3/2022/0967

I am writing to you today 14/12/22 to put my objection forward for the development at Crow Trees Farm Crow Trees Brow Chatburn BB7 4AA /Pringle homes due to the following reasons.

[REDACTED] are writing to you in respect of Application number 3/2022/0966 and the proposal of building 39 homes on Crow Trees Brow, Chatburn by Pringle Homes.

Address of Development: Crow trees farm
Chatburn

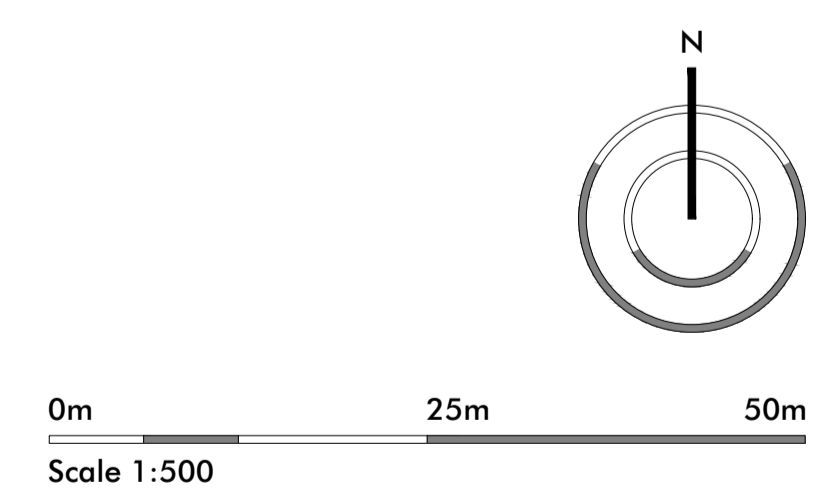
Having looked at the plans it isn't very clear where all the cars are going to park doesn't seem enough parking for the amount of houses being built average 2 cars to each household they will end up parking on the brow this is another concern on the safety aspect on the highway which is already congested causing more danger on the main road into Chatburn village.

- [REDACTED] feel that the proposed number of houses on this site are far too many and that the site is overcrowded. Looking at the plans, there does not appear to be any provision made for visitor parking – would this spill out onto the main road making it even more dangerous?
- The current amenities comprise of a few shops and a school. The school is already over subscribed so where would the additional children that would dwell in these houses go for their education; are [REDACTED] going to be sending them out of the area? There are already busy school bus issues in the area every morning with coaches for Bowland High, Ribblesdale, Stonyhurst, Oakhill etc. As I understand it, the school does not have any further capacity to expand.

The layout of this site is terrible. It is a rigid gridiron pattern of dwellings. They face onto others just like in 19th century northern industrial towns.
